Permitting and Inspections Department
Michael A. Russell, MS, Director

TO: Zoning Board of Appeal Chair and Members
FROM: Ann Machado, Zoning Administrator 
SUBJECT: 122 Anderson Street- 010-H-005
DATE: January 19, 2017

The Practical Difficulty Appeal addresses the area located at the southwest corner of the property at 122 Anderson Street – 010-H-005. The issue is that the pavement in the area has been expanded to the property line without approval either through a site plan application or site alteration permit. The expansion of the pavement to the property line is in violation of section 14-234(h) which states:

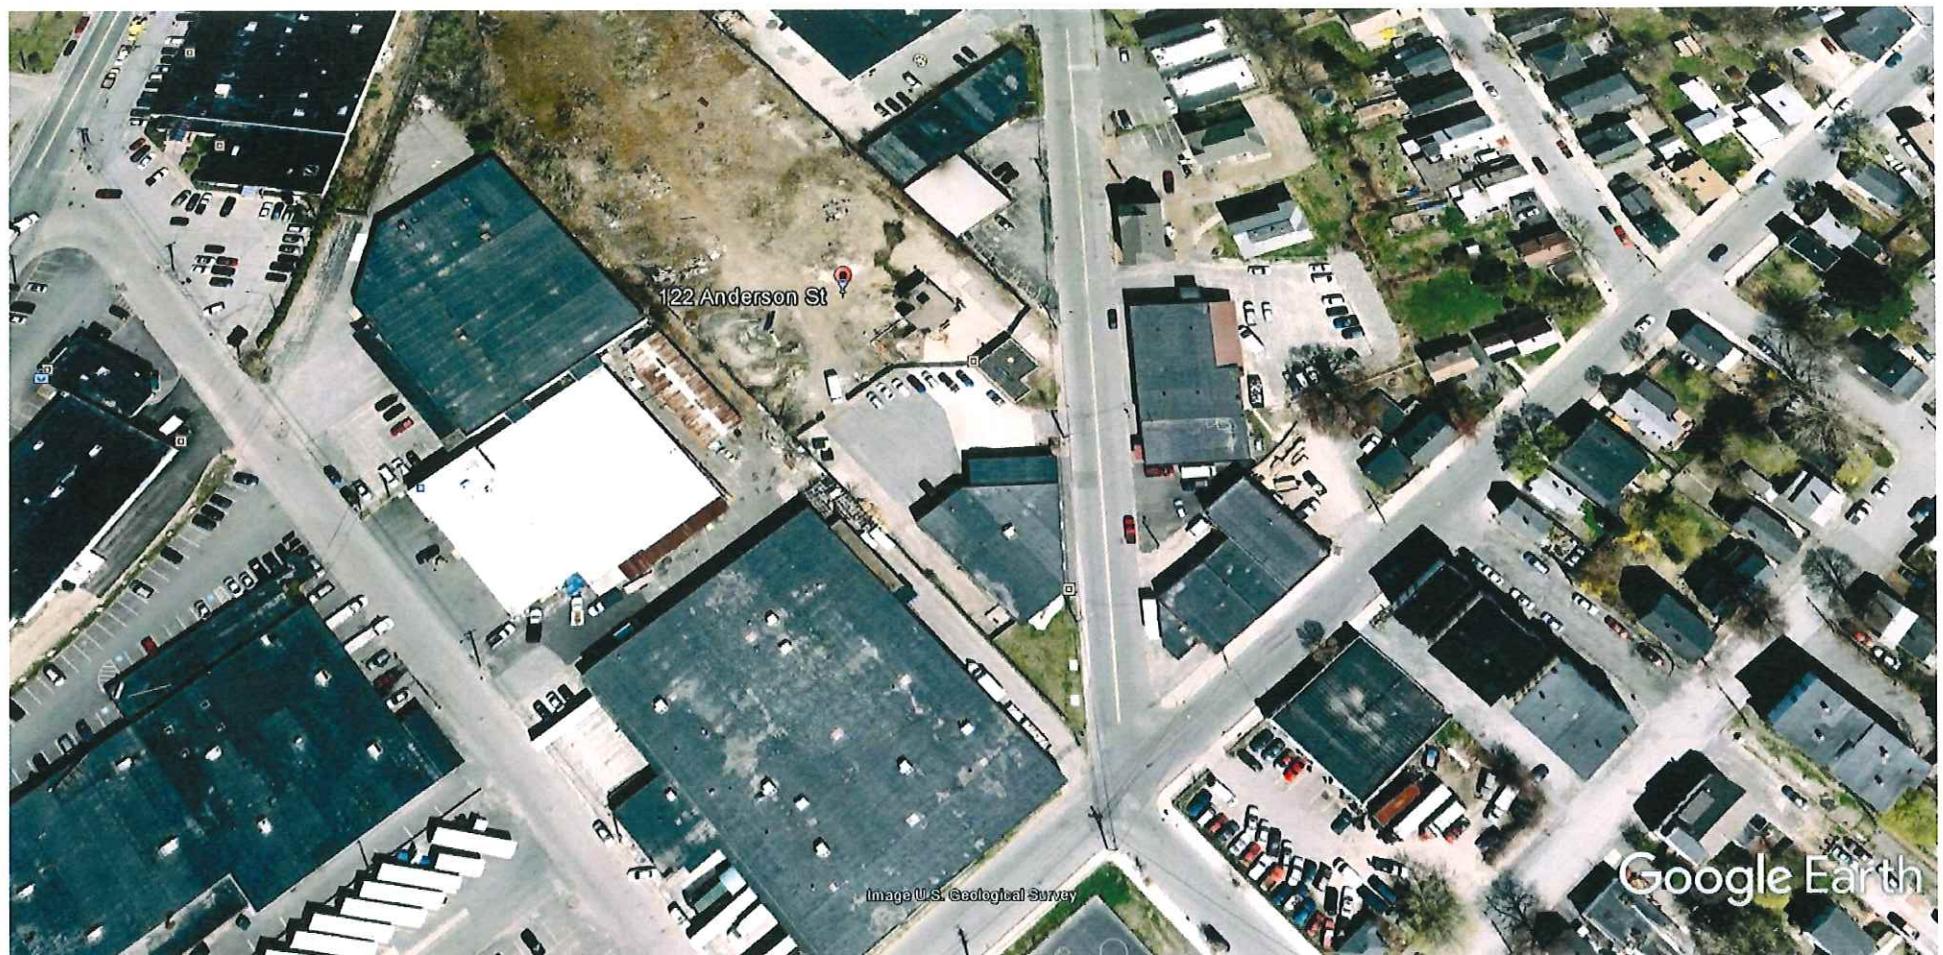
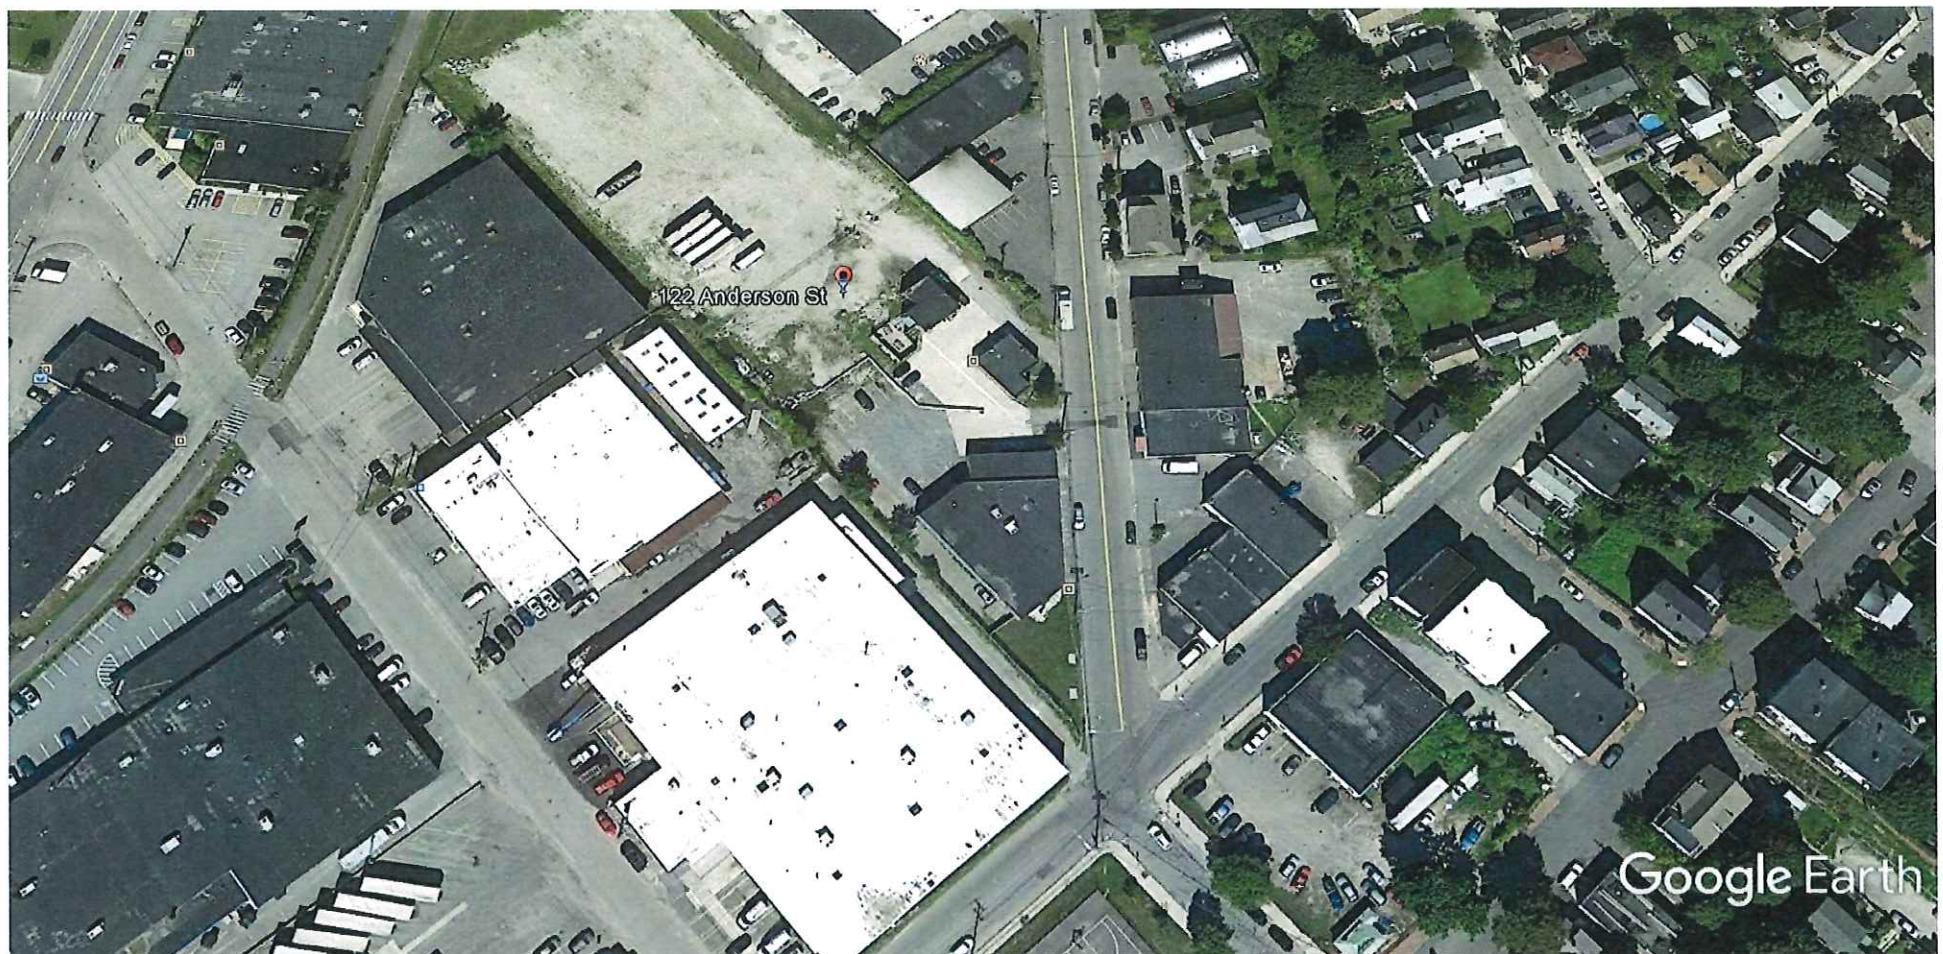
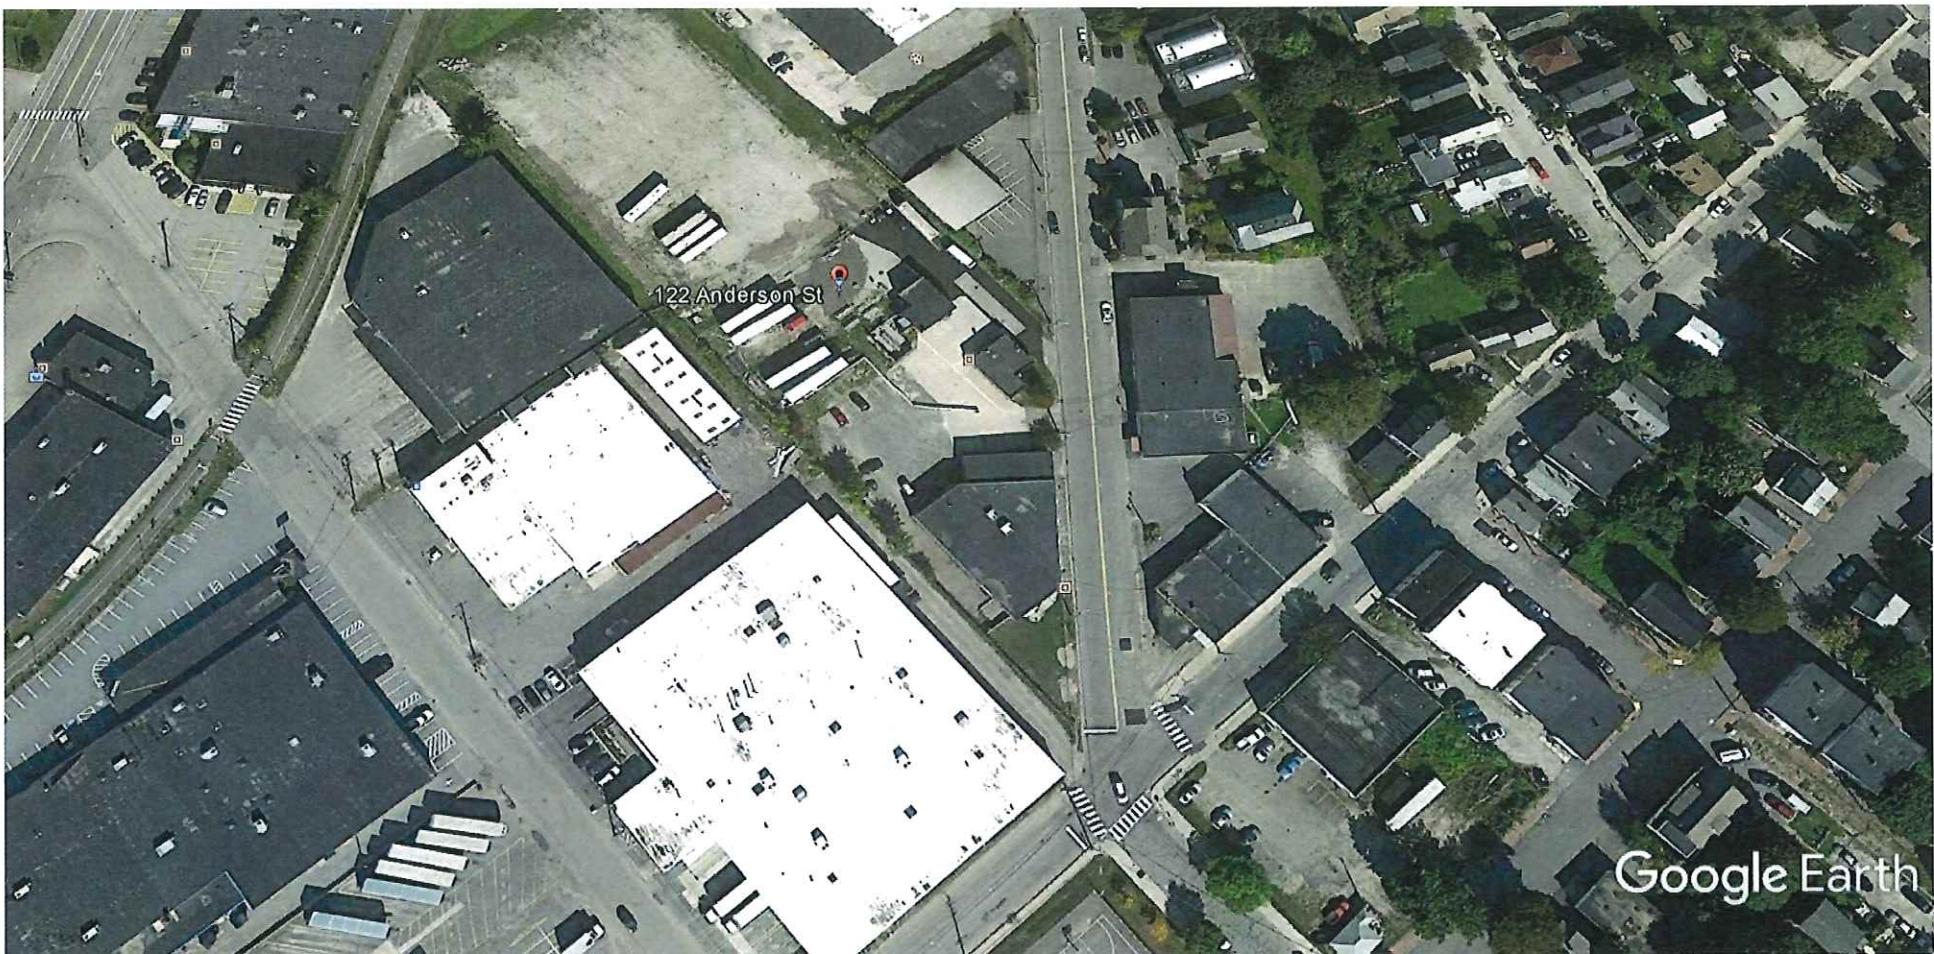
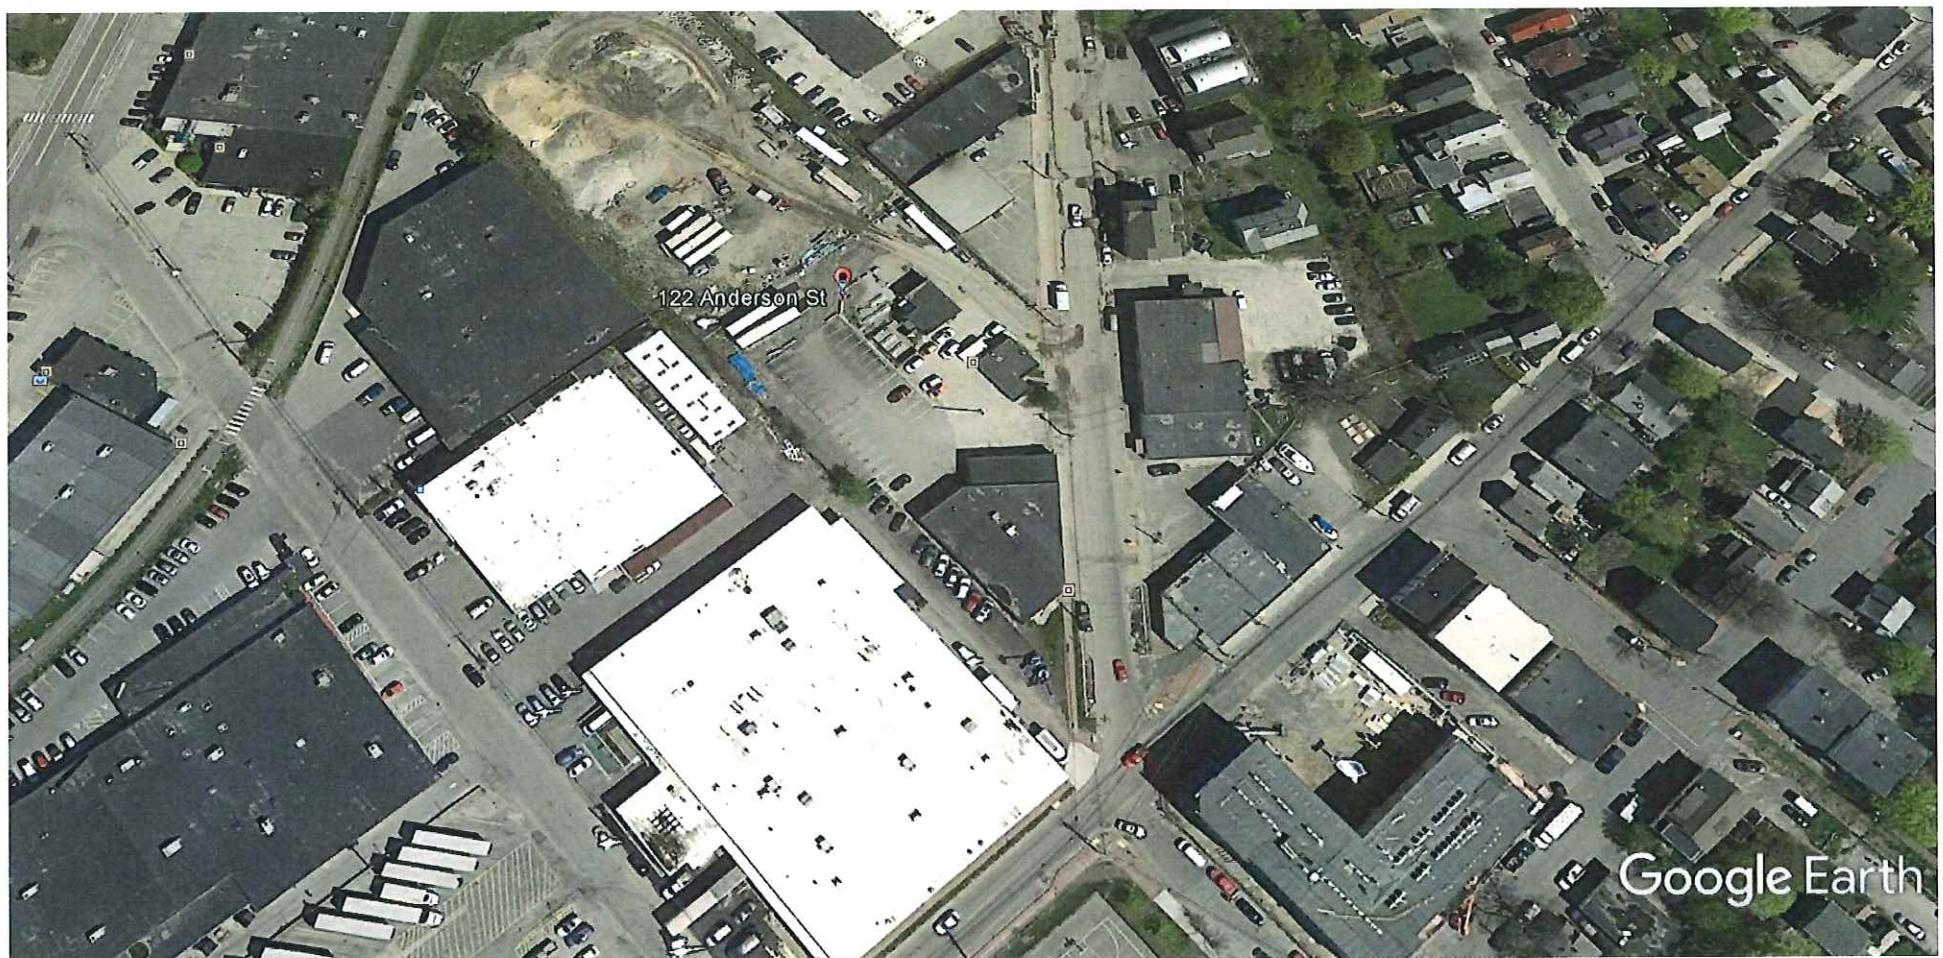
Looking at the Google Earth Images from 2006 to 2016 (Exhibit A), you can see how the pavement has been expanded both up to the southwest property line that abuts the property at 11 Diamond Street – 023-E-006 and towards Anderson Street. The Google Earth Image from 2006 shows an existing paved area to the southwest of the building at 118 Anderson Street - 012-N-004. This paved area did not extend to the end of the building at 118 Anderson Street nor did it extend right up to the property line that abuts 11 Diamond Street. The Google Earth Images from 2006 through 2014 shows a vegetated buffer between the existing pavement of the subject property and the abutting property at 11 Diamond Street and a triangle shaped landscaped area between Anderson Street and the back of the building at 118 Anderson Street.

Exhibit B

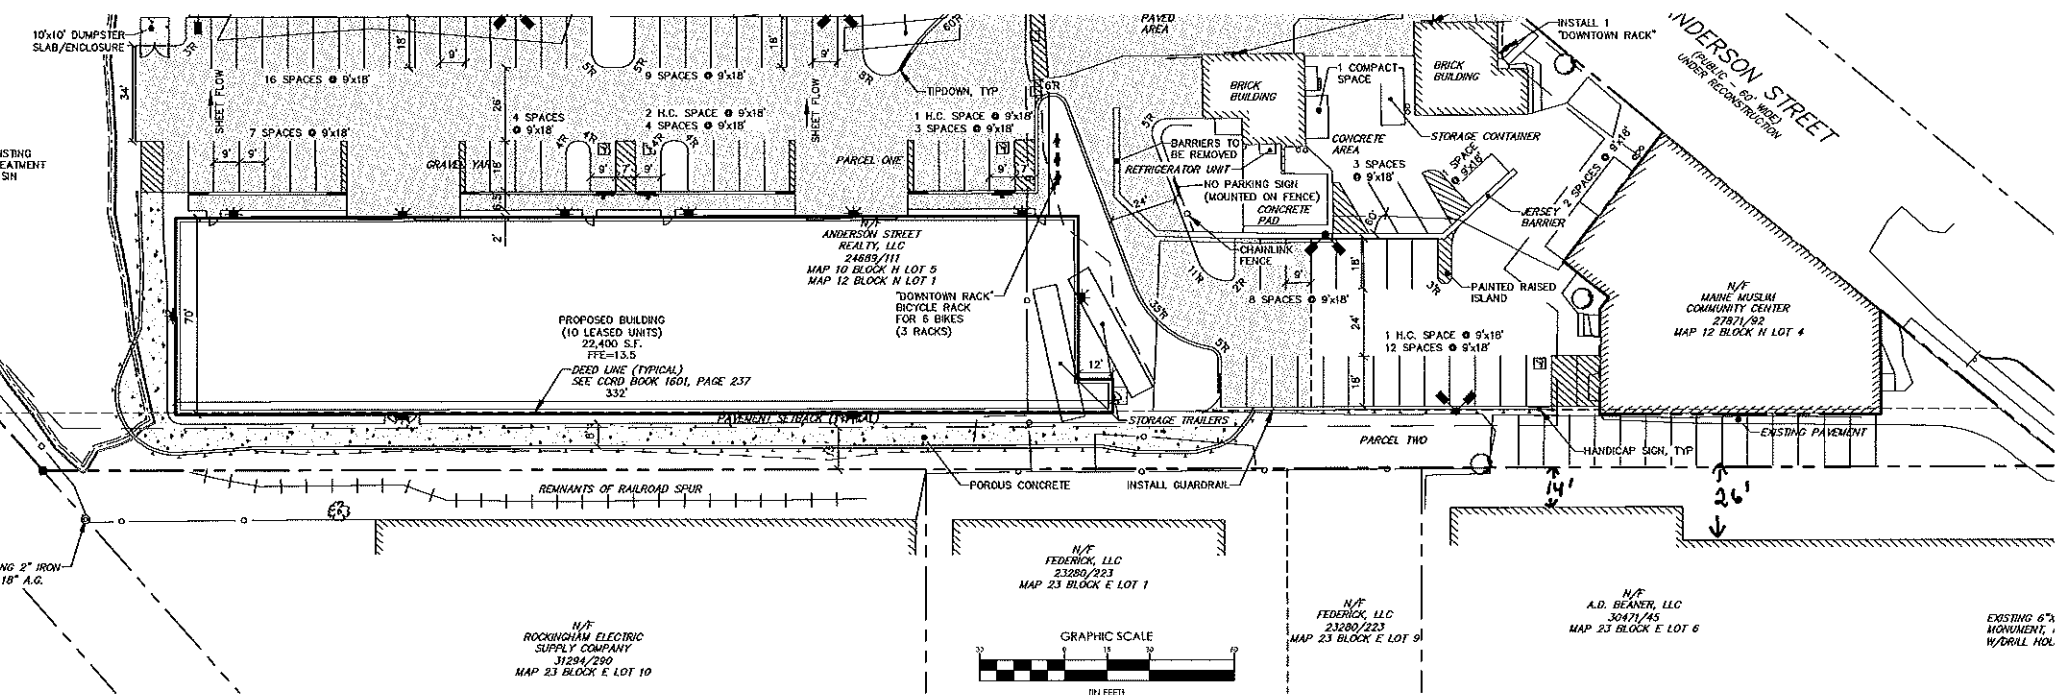
An amended site plan of the property at 122 Anderson Street was submitted to the Planning Division on 12/22/16 (Exhibit B) which shows the existing parking spaces that were created in the expanded paved area. Based on this site plan, the distance between the rear property line and the building at 11 Diamond Street scales at 26' and at 14' where the rear part of the building bumps back. Section 14-352 (Exhibit C) gives the dimensions of a loading bay as 14' x 50'. There appears to be enough area to the rear of the building at the 11 Diamond Street property for loading and unloading without encroaching on the subject property at 122 Anderson Street.
